20170038.4/1005A/R1/TA

Western Sydney Stadium (Project No 255417) - Stage 2 DA - Response to EPA & DOP

This letter presents a response to queries raised by the NSW Environmental Protection Authority and Department of Planning in letters dated 7 April 2017 and 13 April 2017 respectively.

1.1 EPA COMMENTS – LETTER EF16/2911, DOC152571-01

**Figure 3 – SoundPLAN Western Sydney Stadium Noise Model**

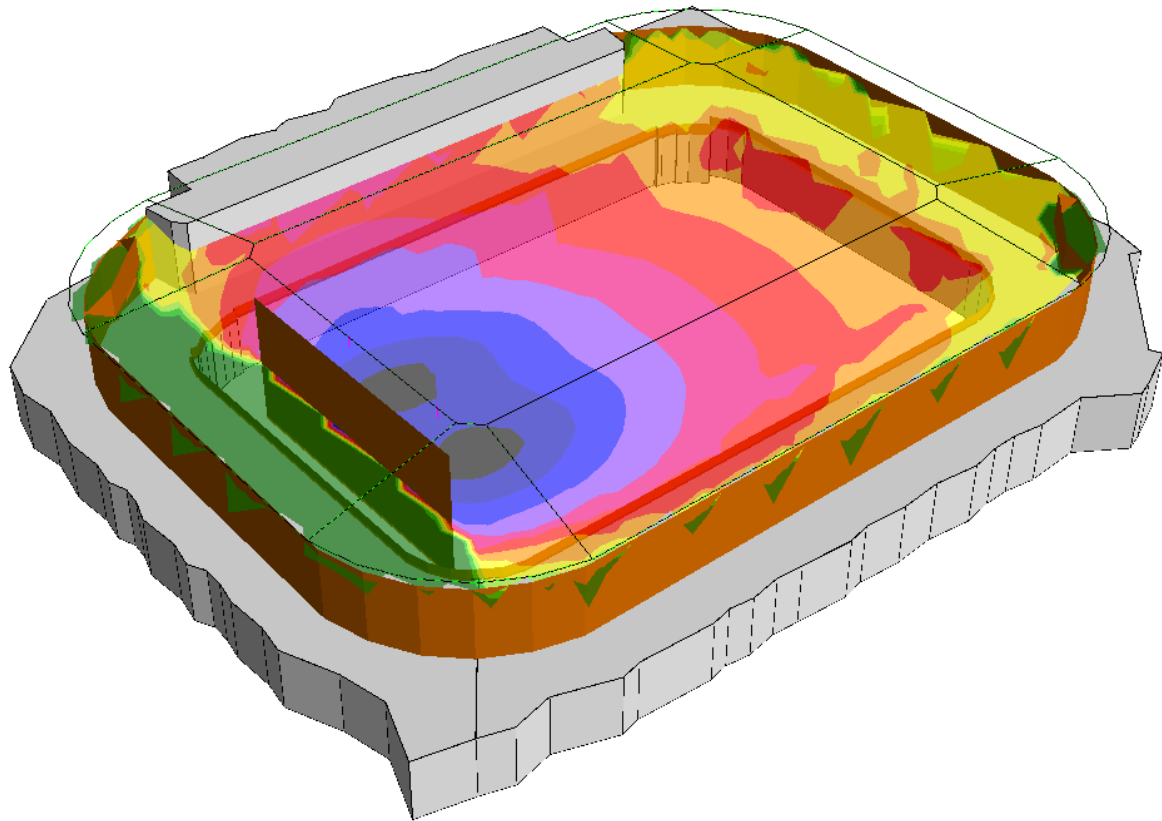
Figure 3 of the EIS Appendix S 'Operational Noise and Vibration Impact Assessment' appears to show a simple model of the stadium, with seating tiers represented by vertical barriers and no open space between tiers. However, EIS architectural drawings appear to show a stadium structure that is open behind the tiers, with various gaps between the lower and upper tiers. For example, the EPA notes what appears to be a gap along the whole eastern side of the stadium which side faces the most affected noise sensitive receivers.

The EPA considers it essential for assuring the accuracy of predicted operational noise levels that the proponent clearly demonstrate that the noise model is appropriately detailed, including the taking into account of any gaps between seating tiers.

The developed SoundPLAN model is significantly more detailed than the Stage 1 model and accurately predicts noise emissions from the current stadium planning. The level of detail presented within the REVIT model cannot be replicated within the SoundPLAN model due to the limitations of the modelling software (ie it is not architectural software). That being said, architectural minutia will not have an impact on the predicted noise level given: a) the predominant noise source is the open roof; and b) the relatively significant distance of the receivers from the stadium. The gaps between the roof and rear of the seating tier, etc, at the stadium perimeter have been included in the model. It is noted that the predominant noise source is the hemispherically radiating open roof.

## APPENDIX ONE – SOUNDPLAN NOISE CONTOURS

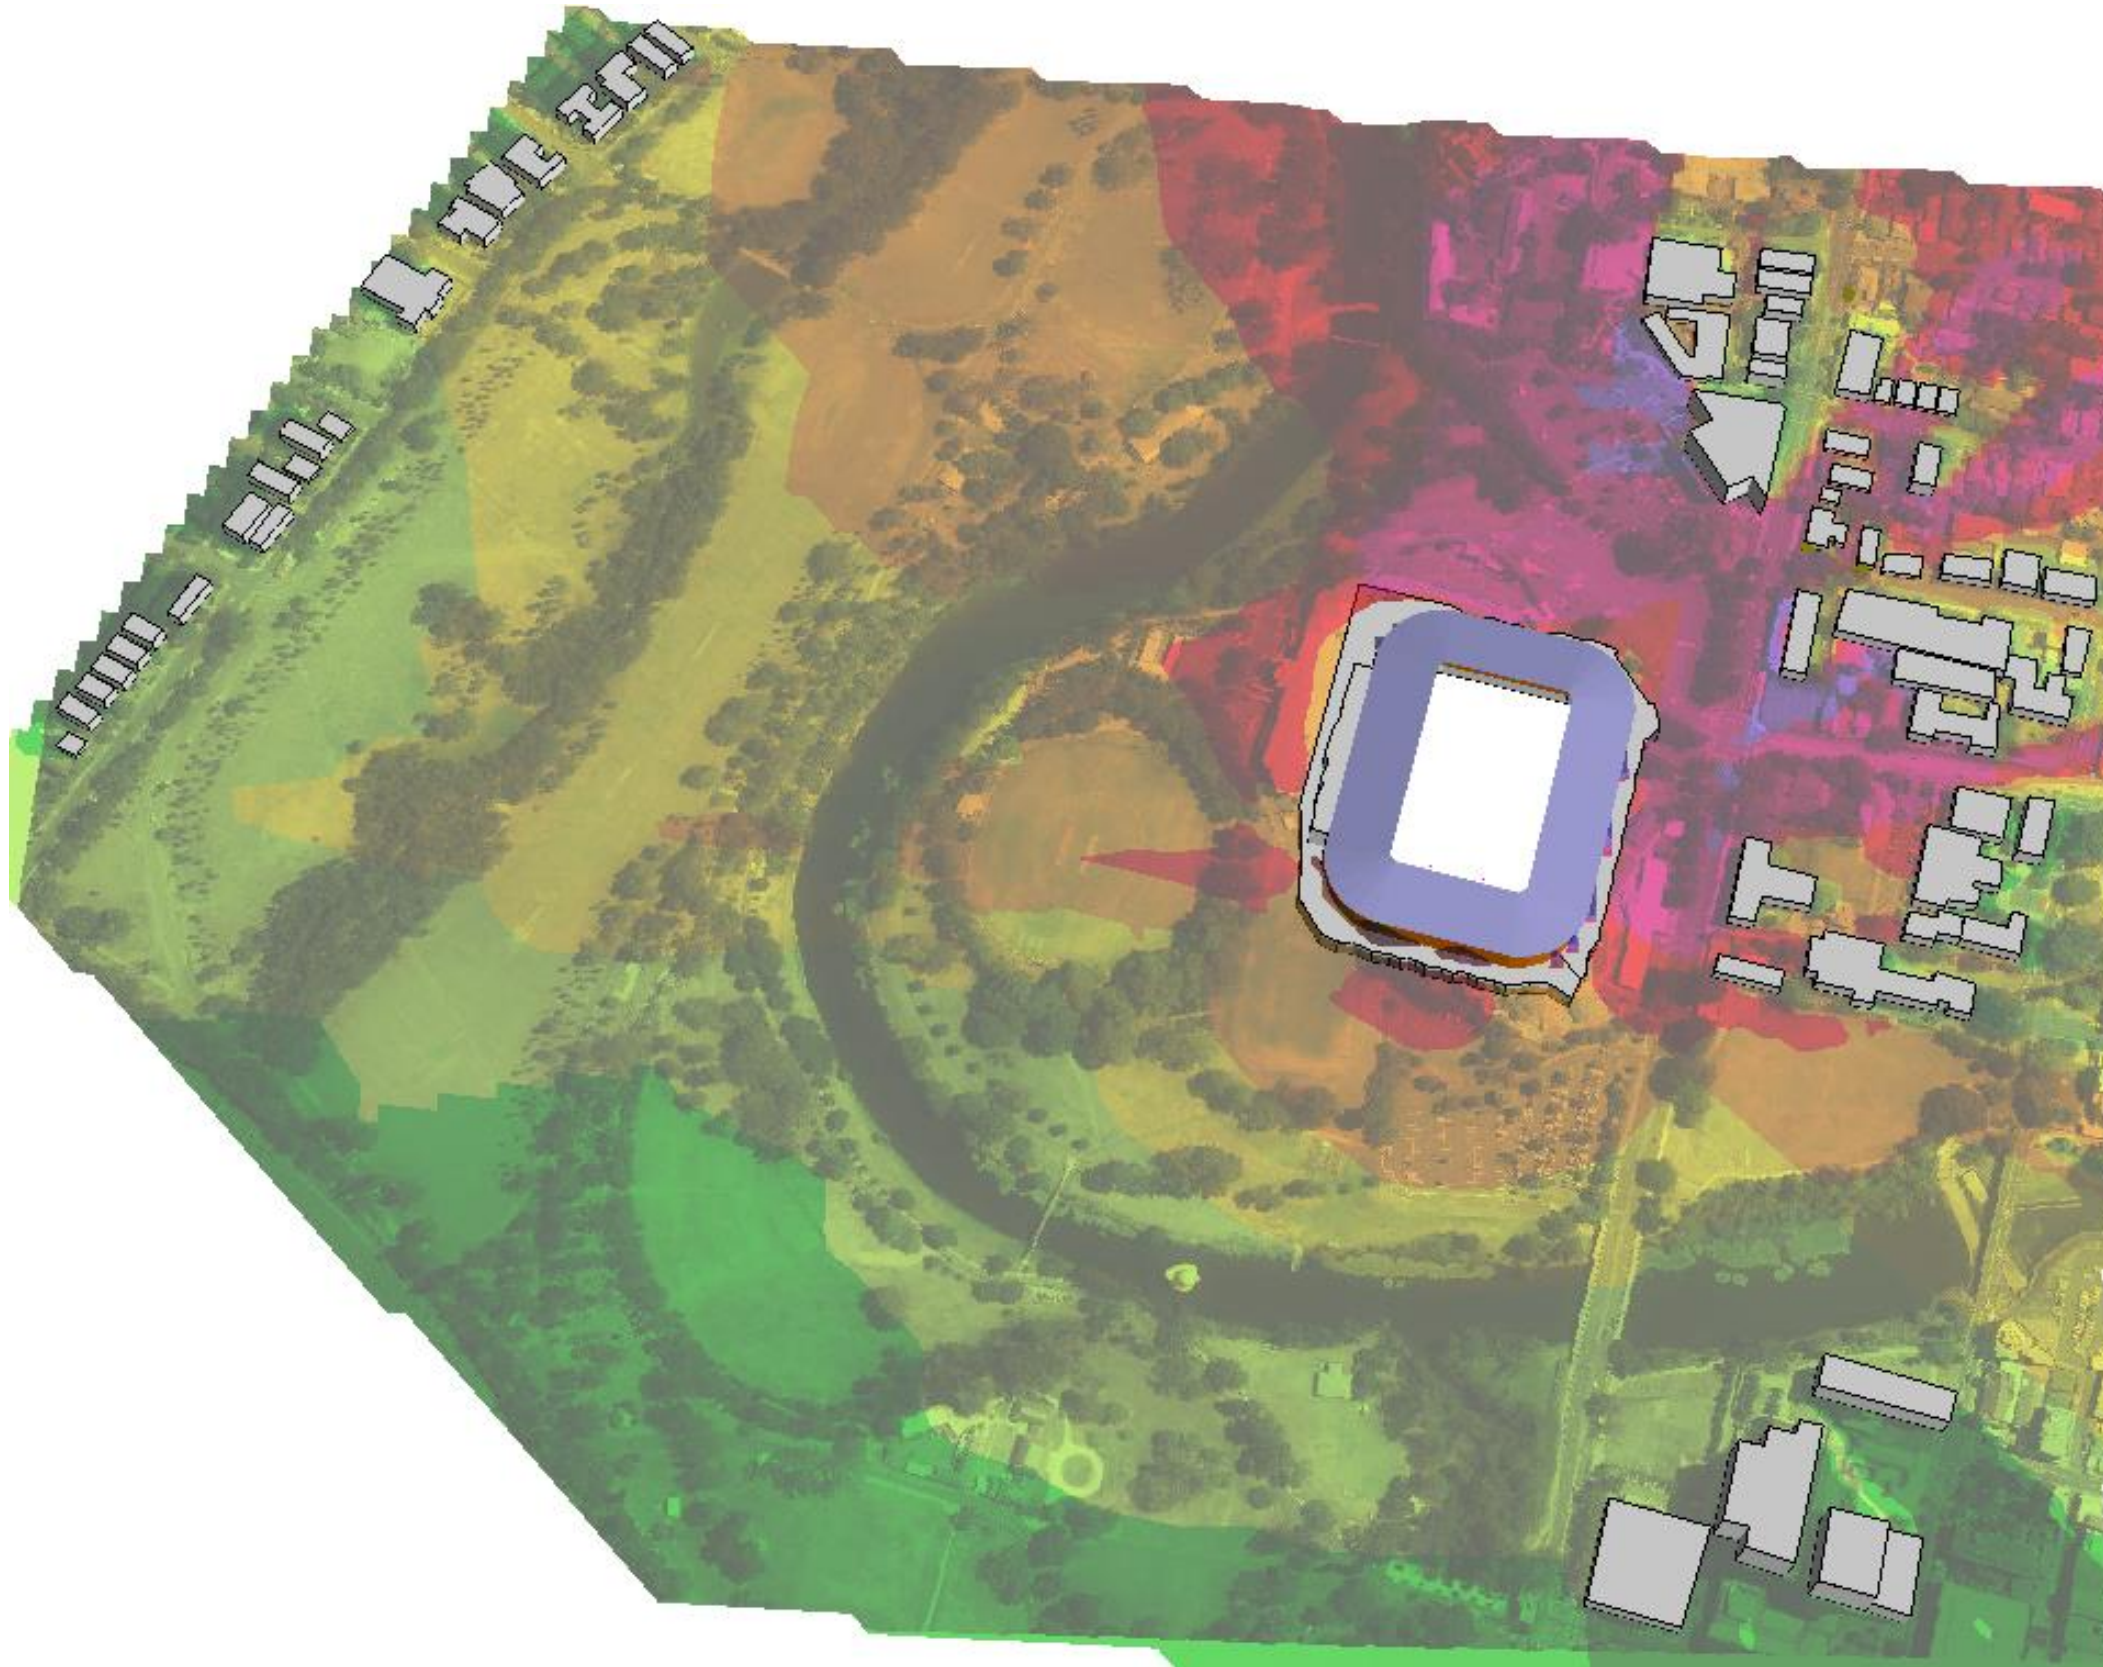
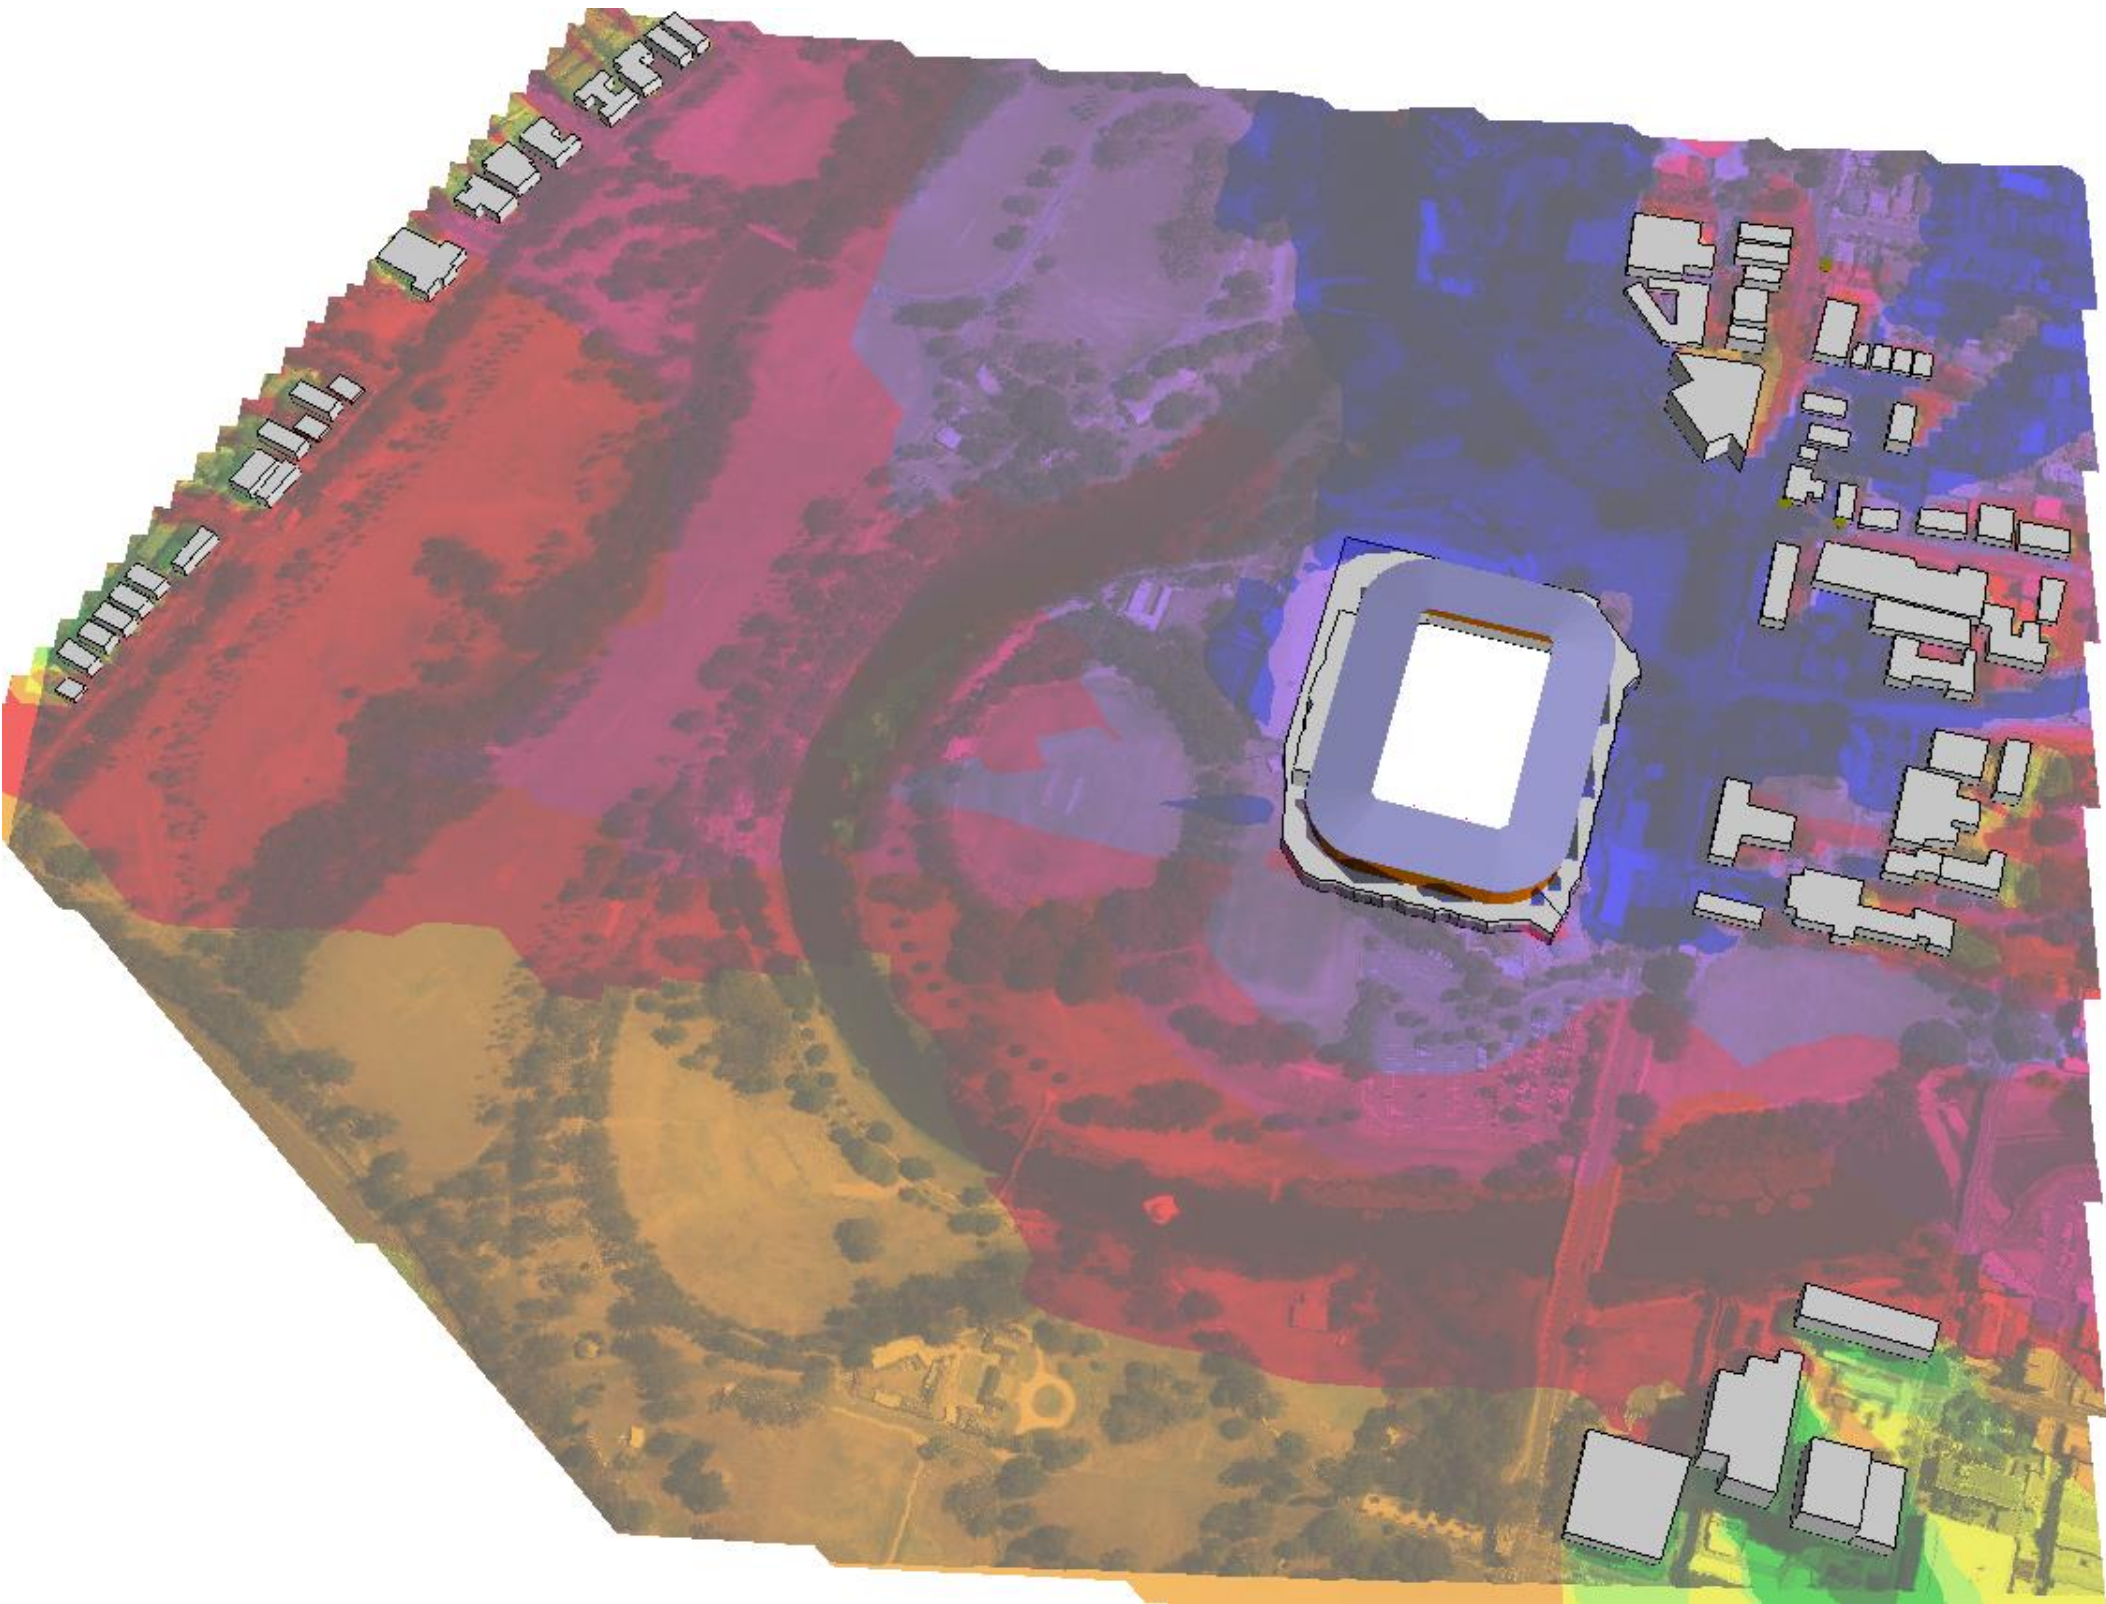
- (a) tabulated data using the various recommended A and C weighted noise descriptors required to facilitate proper evaluation of those predicted noise impacts, and
- (b) details of predicted day-time noise impacts on non-residential noise sensitive land uses, including local schools, the nearby child care facility and the nearby place of public worship (St Patricks Cathedral).

The impacts on all land uses are detailed in the requested "*marked up orthophoto maps showing the predicted noise levels contours for various proposed activities*"

The predicted daytime noise levels for events are the same as the night time events, as ultimate noise levels from concerts, crowds, sporting events, etc are not dictated by the ambient environment.
